Letter No. **A2/39875/2004**

Sub: **CMDA - Planning Permission - Construction of Ground Floor + First Floor Residential Building with 2 dwelling units at Plot No.133B, Balaji Nagar, S.No. 412 part, 412/9 (patta) of Nerkundram village - Development charges and other charges to be remitted - Reg.**

**GROUND FLOOR PLAN - Scale 1"= 8' 0"(1:100)**

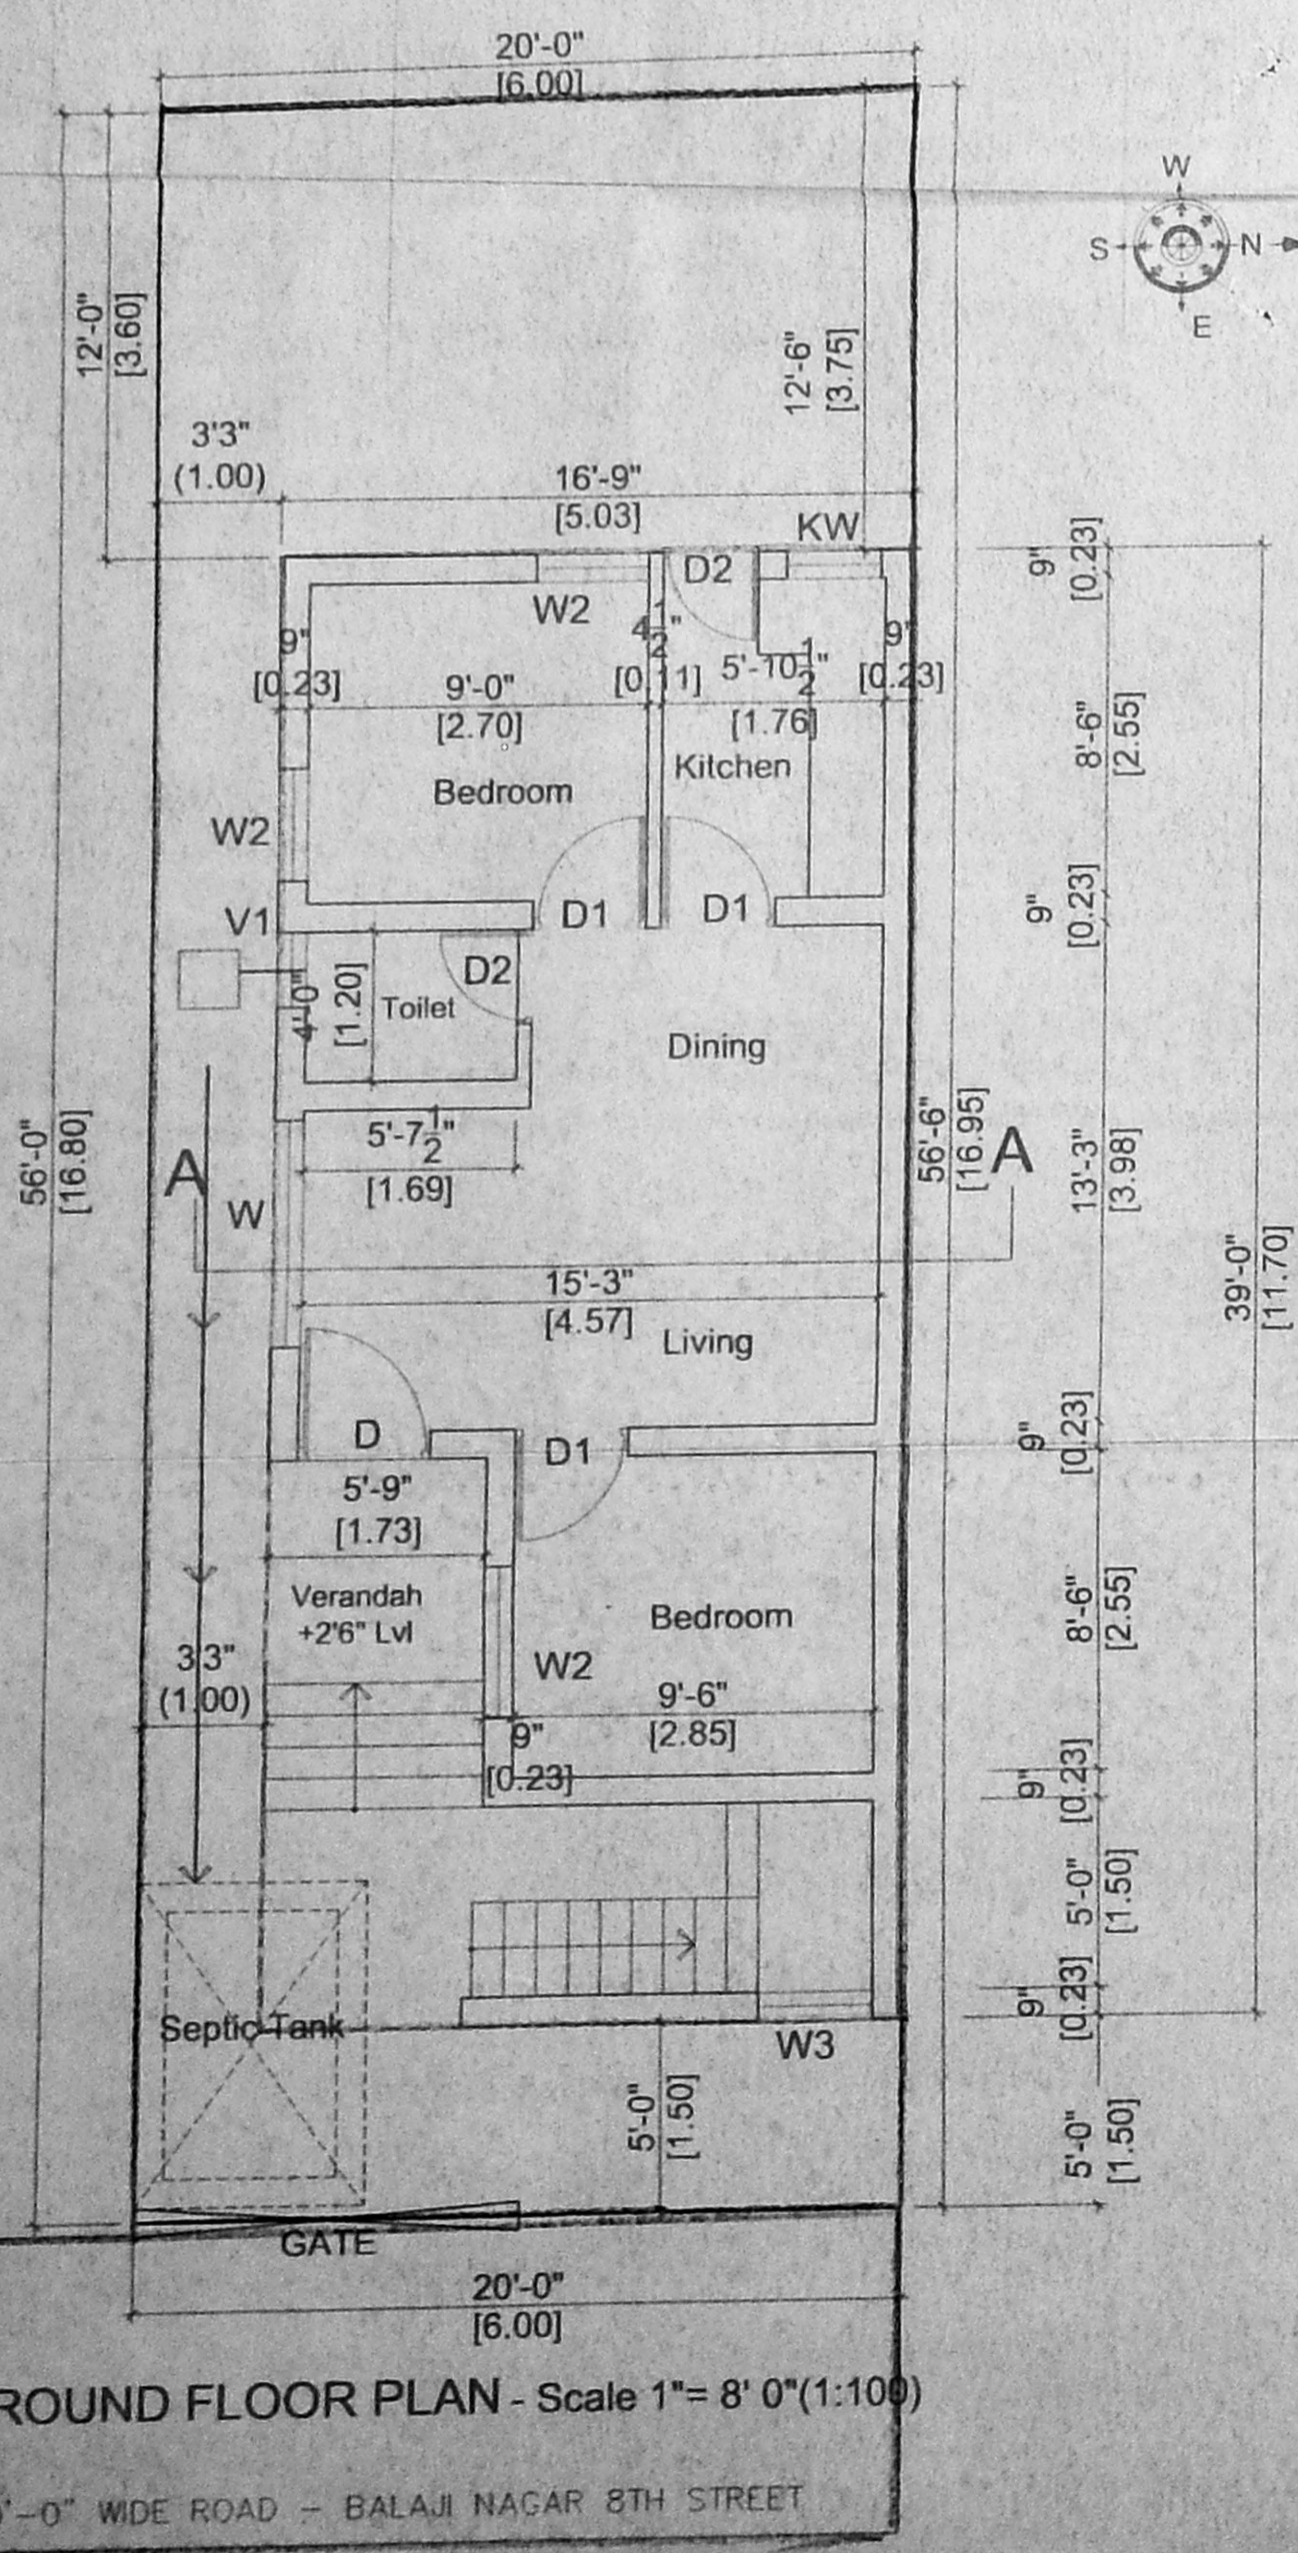
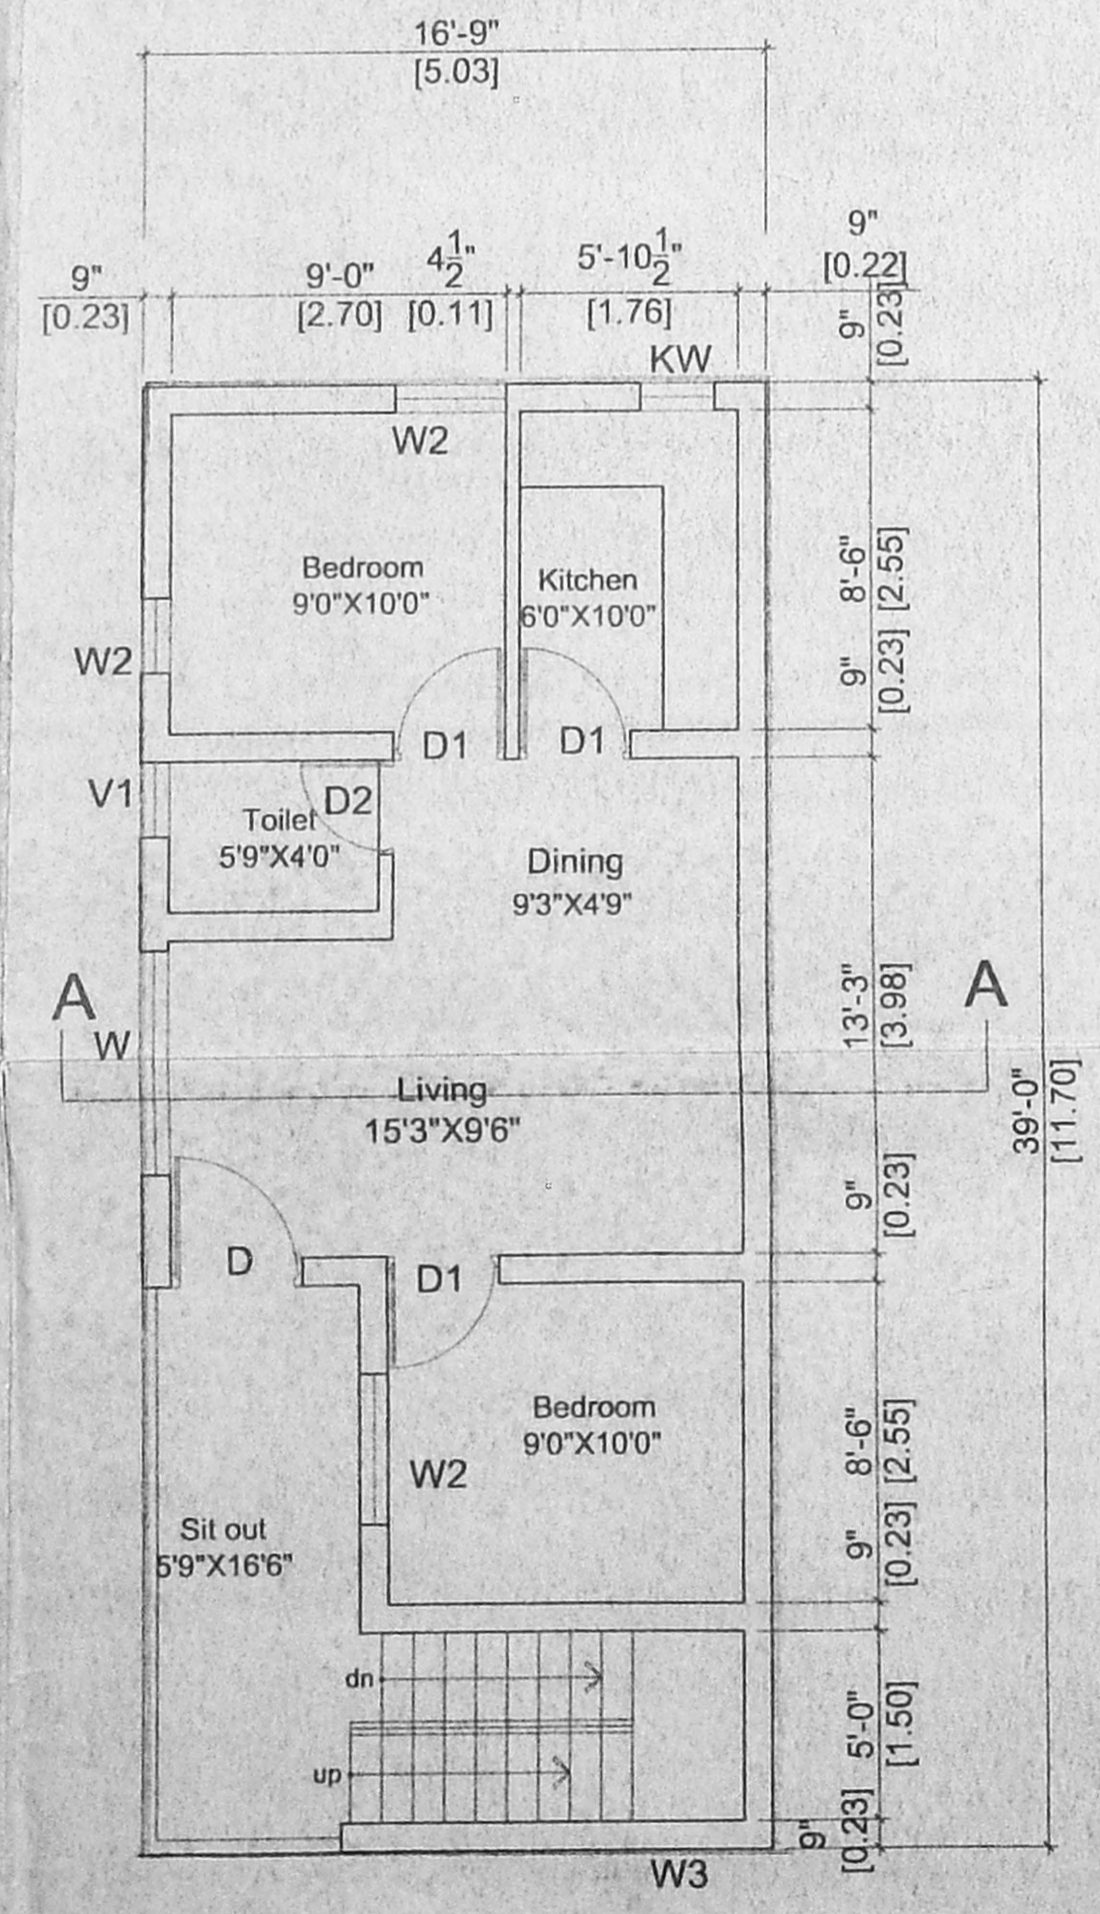
b. **The Residuary plot details to be shown in separate sheet, deleting the same in the proposed plan.**
